A47 North Tuddenham to Easton Dualling

Volume 2 **2.12 Hedgerow Plans**

The A47 North Tuddenham to Easton
Development Consent Order 202[x]

Version	Date	Status of Version
Rev. 0	March 2021	Application Issue
Rev.1	October 2021	Deadline 3 Issue
Rev.2	December 2021	Deadline 6 Non-Material DCO Change Request
Rev.3	January 2022	Deadline 8 Update
Rev.4	February 2022	Deadline 9 Update

DRAWING NUMBER
HE551489-GTY-LSI-000-DR-CH-40004

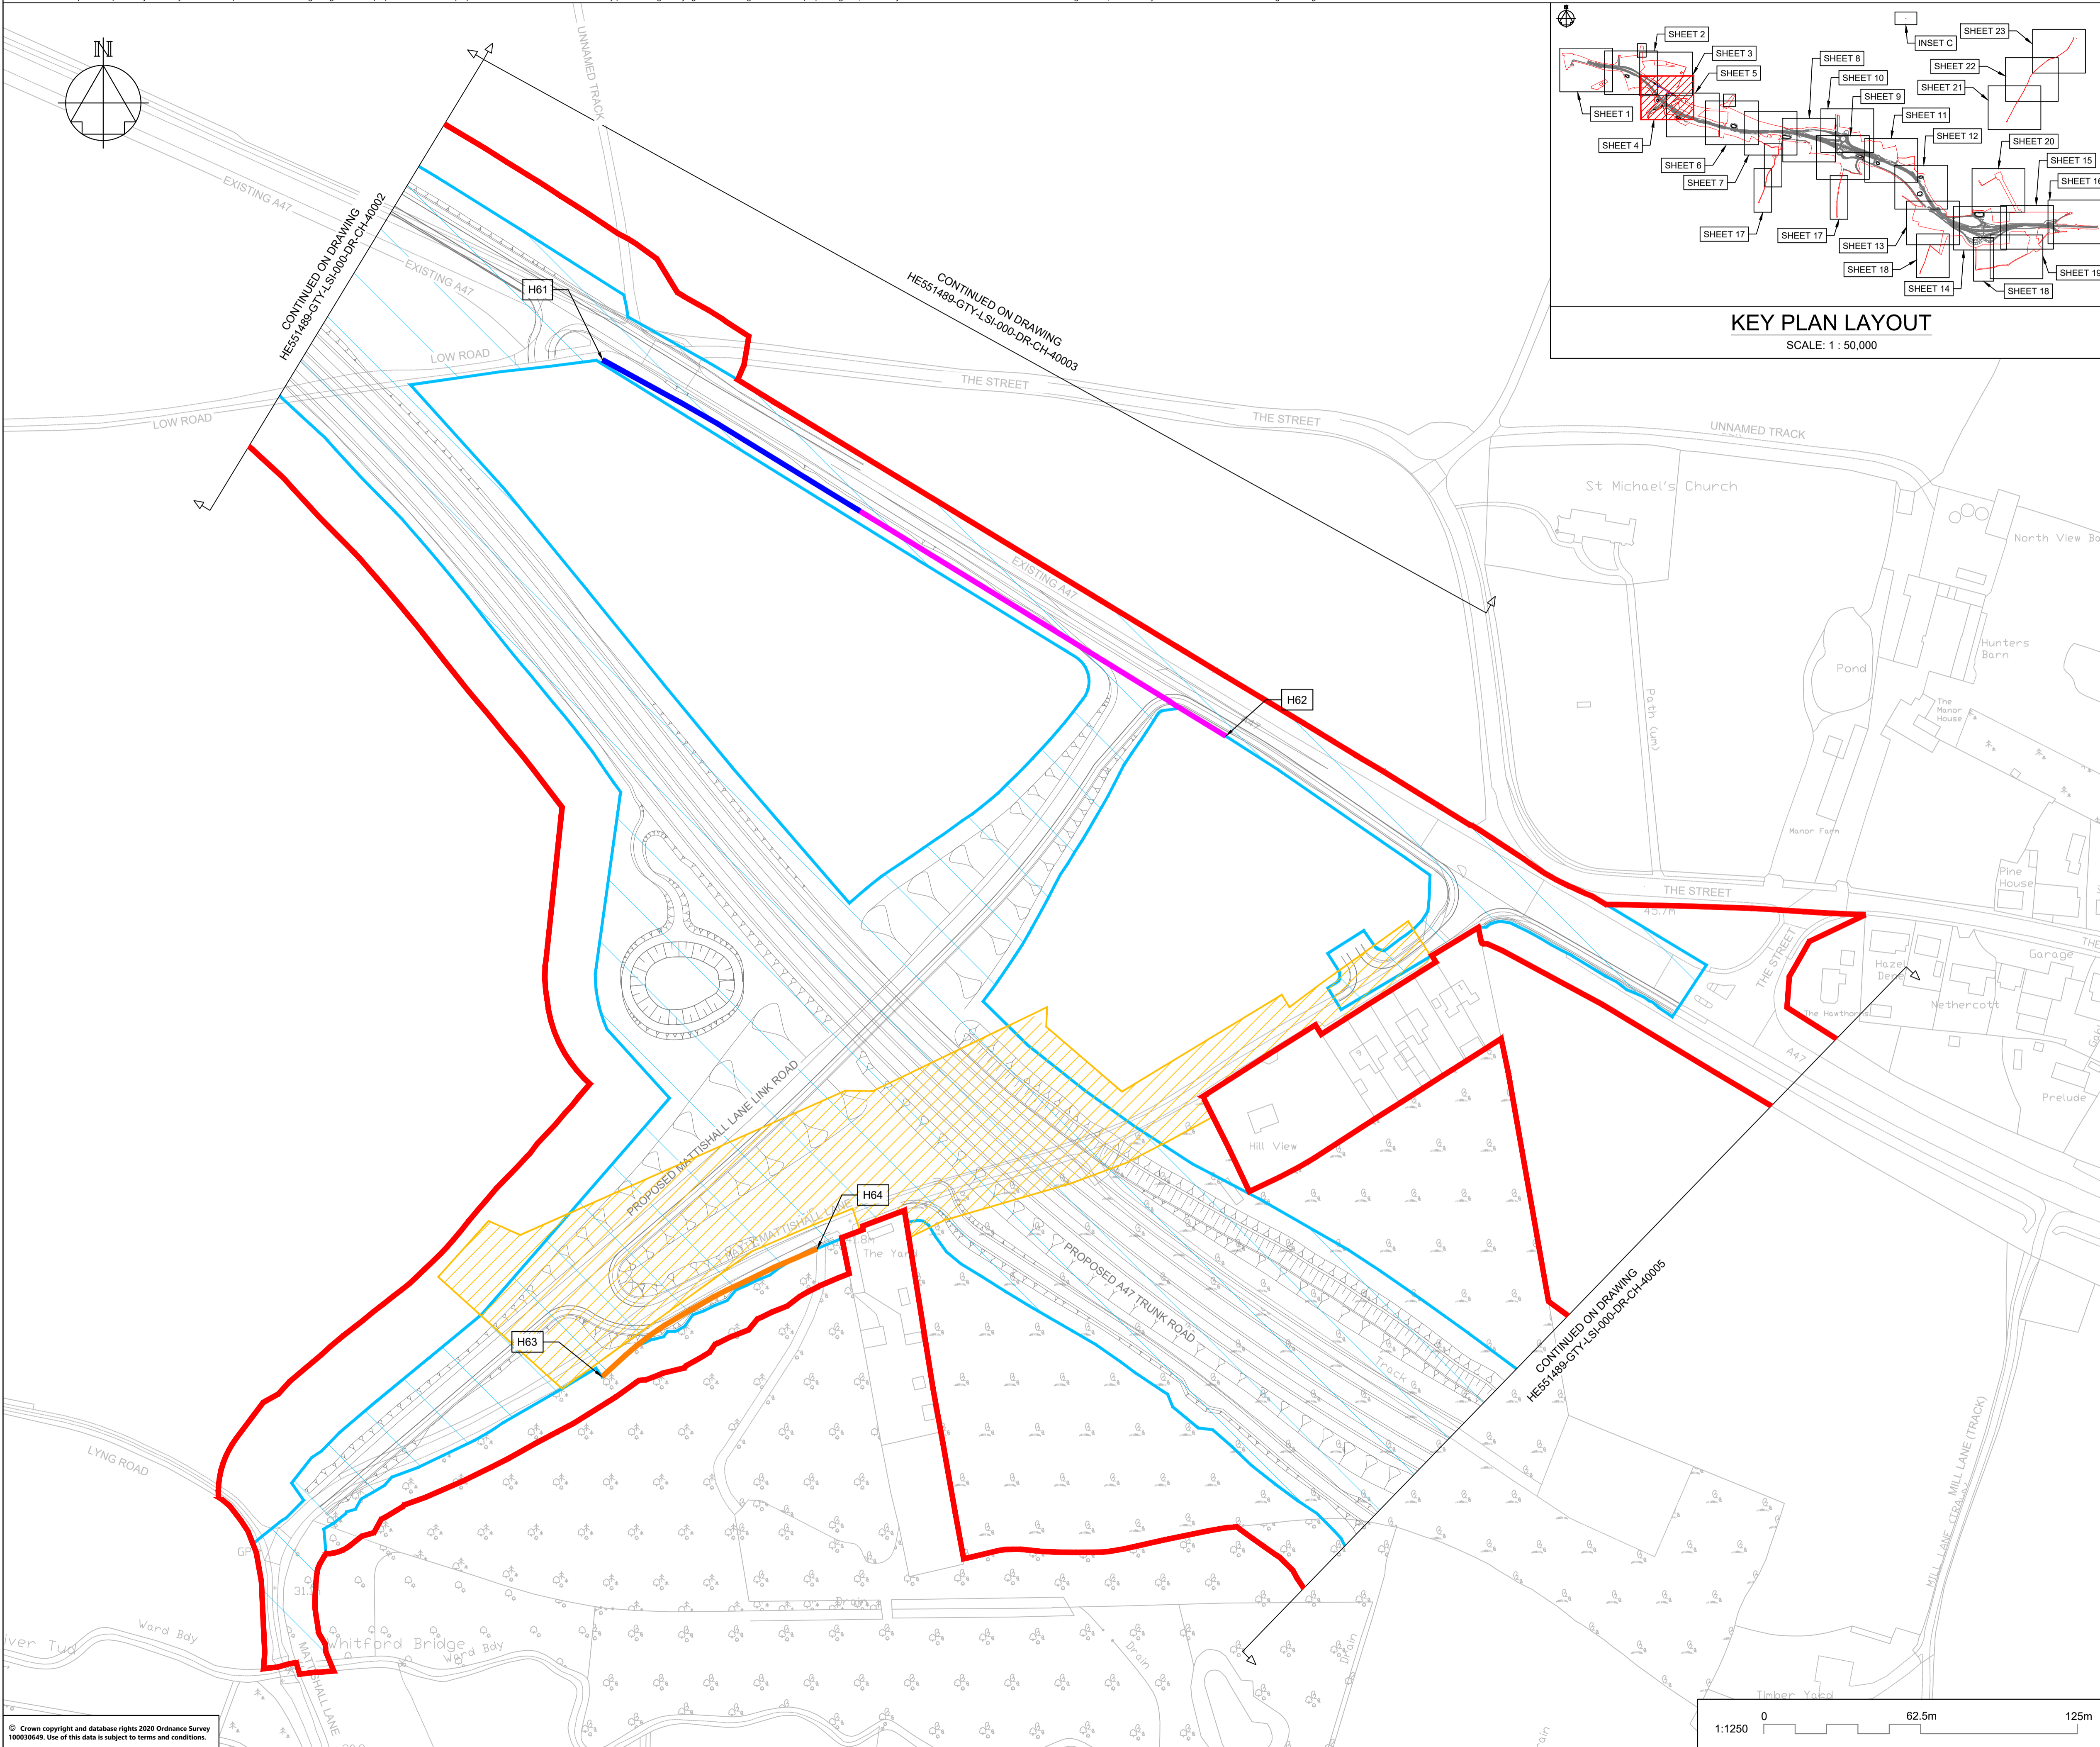
- 3.1.1 The Key Plan and drawing sheets 2, 4, 9 and 14 have been updated to reflect the following changes proposed in the Non-Material DCO Changes Request (**TR010038/EXAM/9.26**) submitted to the Examining Authority:
- Relocation of Lyng Road drainage basin access track.
 - Alteration to the existing A47 and Mattishall Lane Link Road junction to allow a ghost island.
 - Alteration of the existing A47 and Dereham Road junction to allow a ghost island, with associated alteration to the adjacent drainage basin and its access track.
 - Adjusted Berrys Lane highway limit of deviation for the proposed drainage along Berrys Lane, and amend the material storage area north of Berry Hall.
 - Adjusted the highway limit of deviation for Taverham Road drainage basin to support inclusion of a wetland area.

DRAWING NUMBER
HE551489-GTY-LSI-000-DR-CH-40009

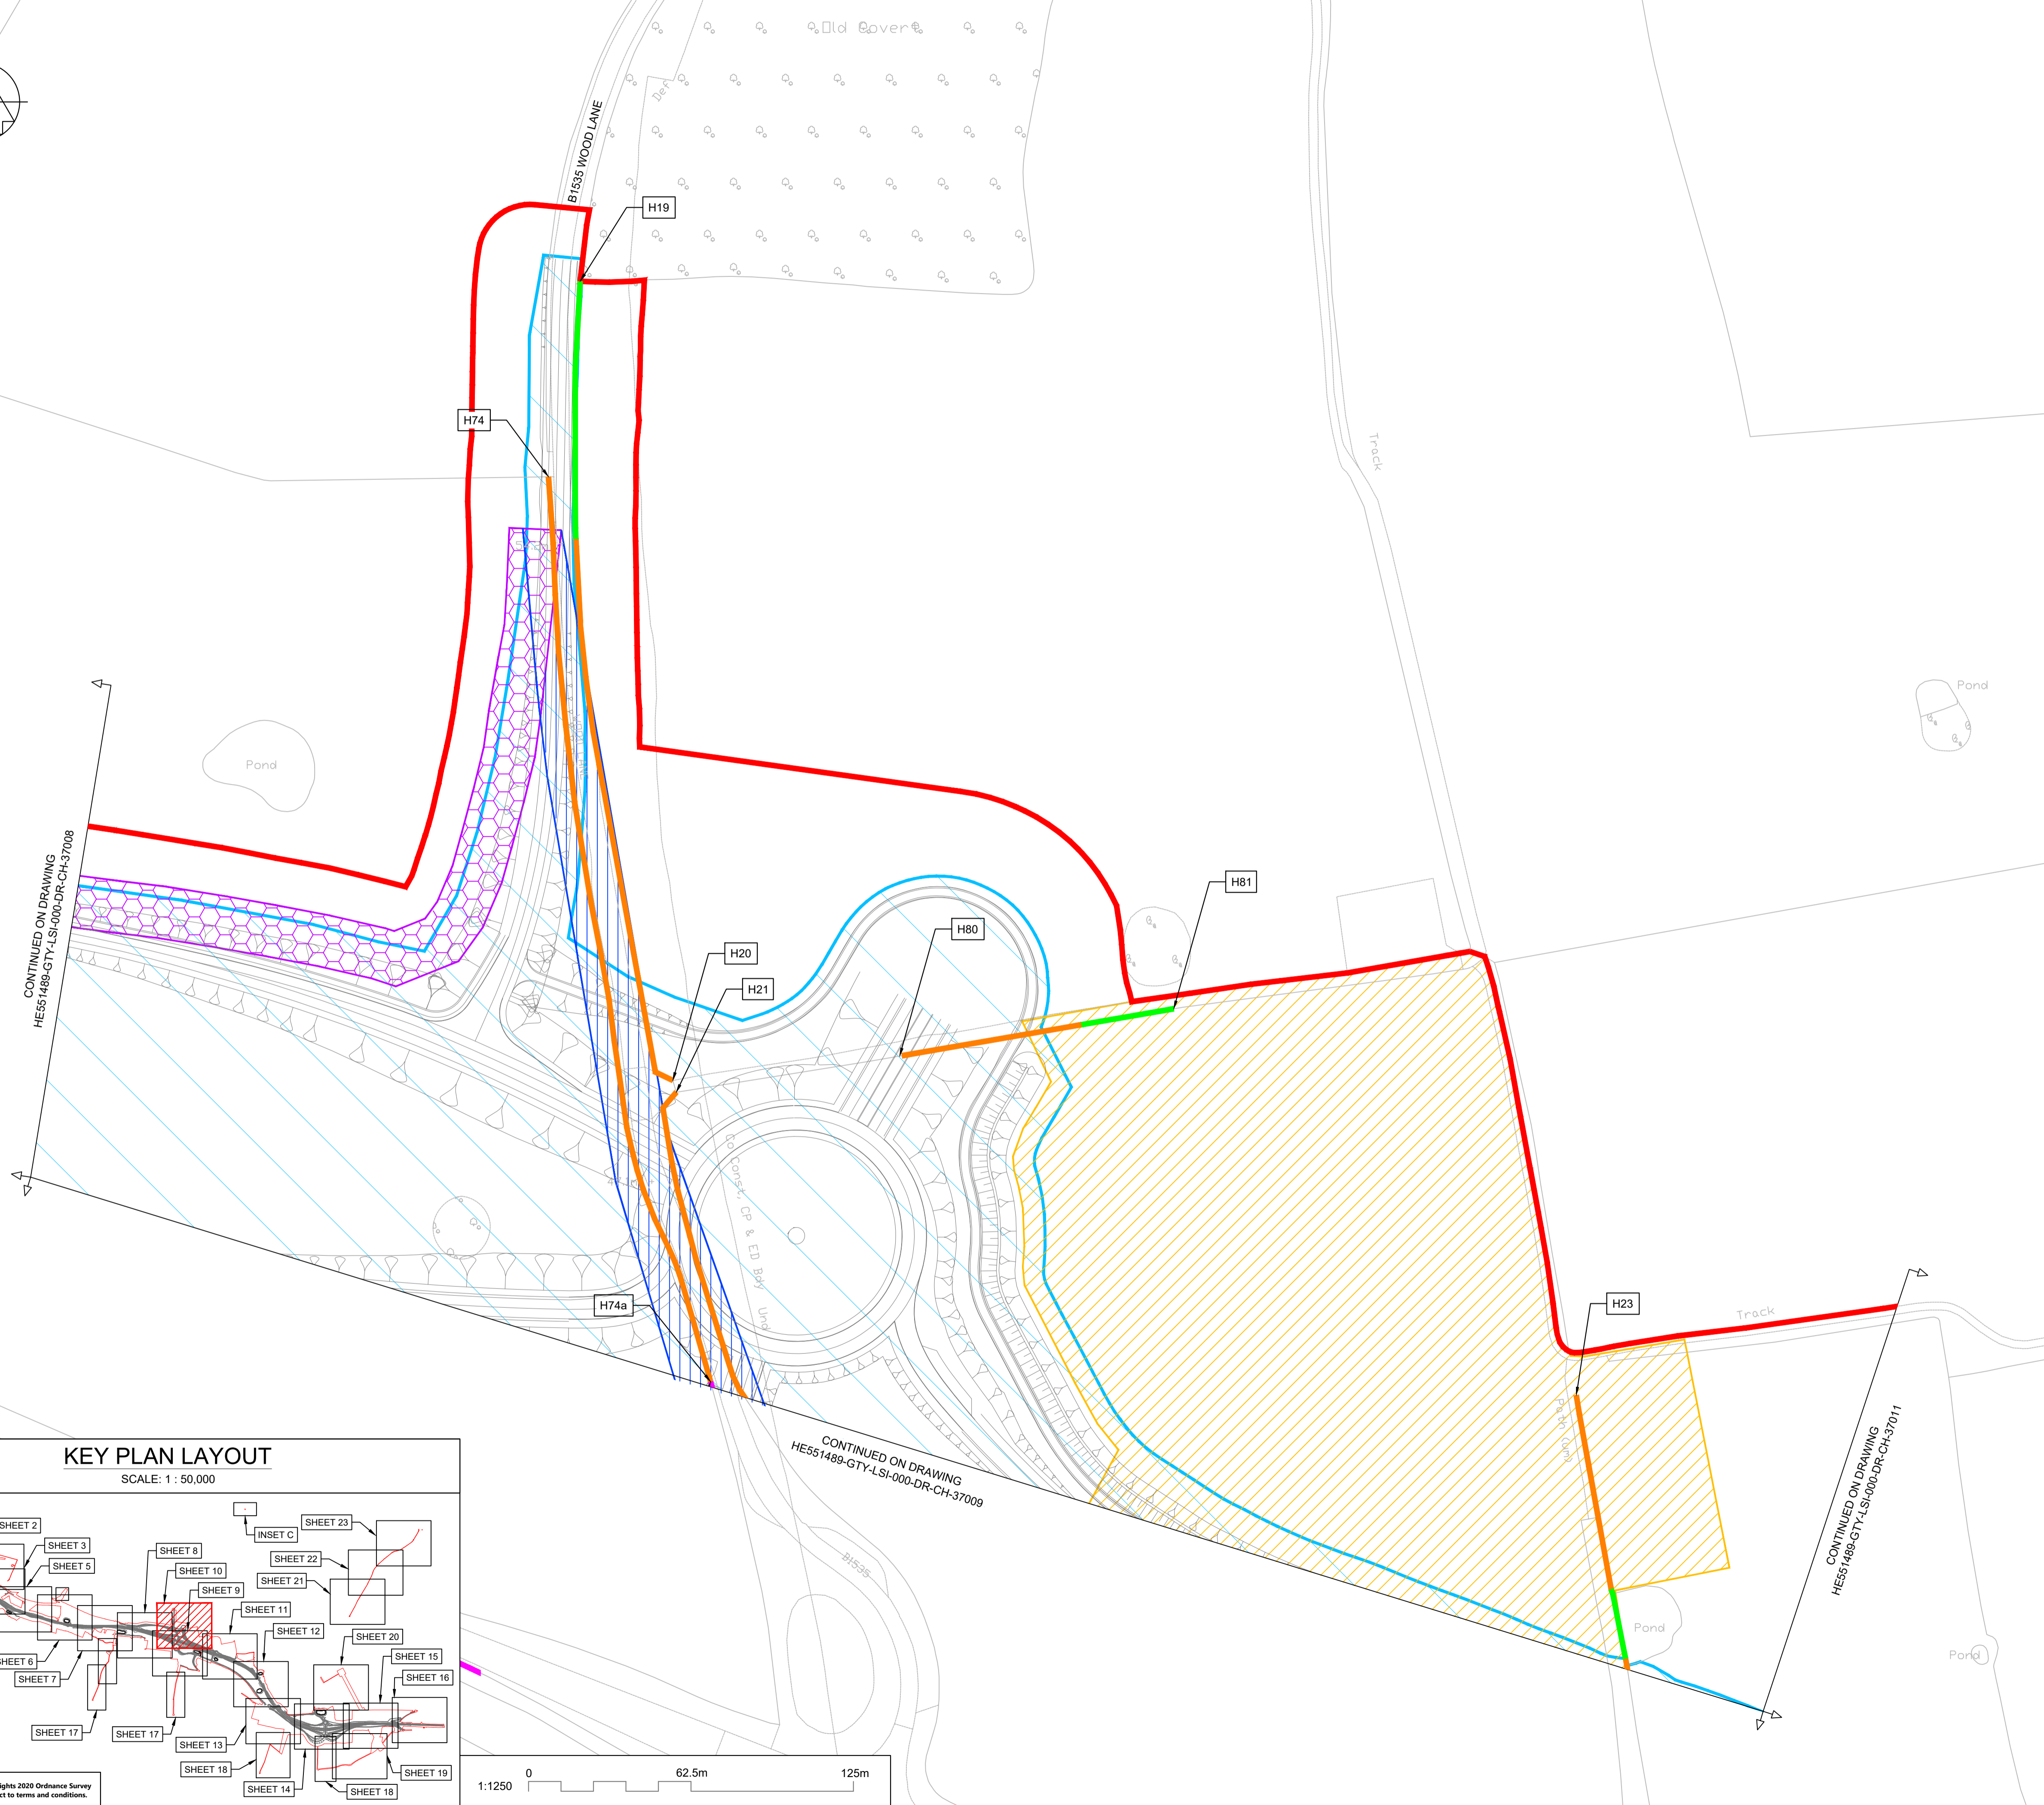
- 2.1.1 The Key Plan and drawing sheets 9 and 14 have been updated to reflect the below changes to the Scheme design. The changes to the design and limits of deviation all remain within land allocated for permanent acquisition to deliver the Scheme:
- Alteration of the proposed existing A47 and realigned Taverham Road junction to remove any permanent works within land parcel 14/6a, in response to commitments in RR-006, RR-006 and RR-006 in the Applicant’s Responses to the Relevant Representations (**REP1-013**).
 - Illustrate the change between the 3m wide RB1 byway connection to a 2m wide cycle only along the south side of the existing A47, in response to commitments in RR-037.59 in the Applicant’s Responses to the Relevant Representations (**REP1-013**).
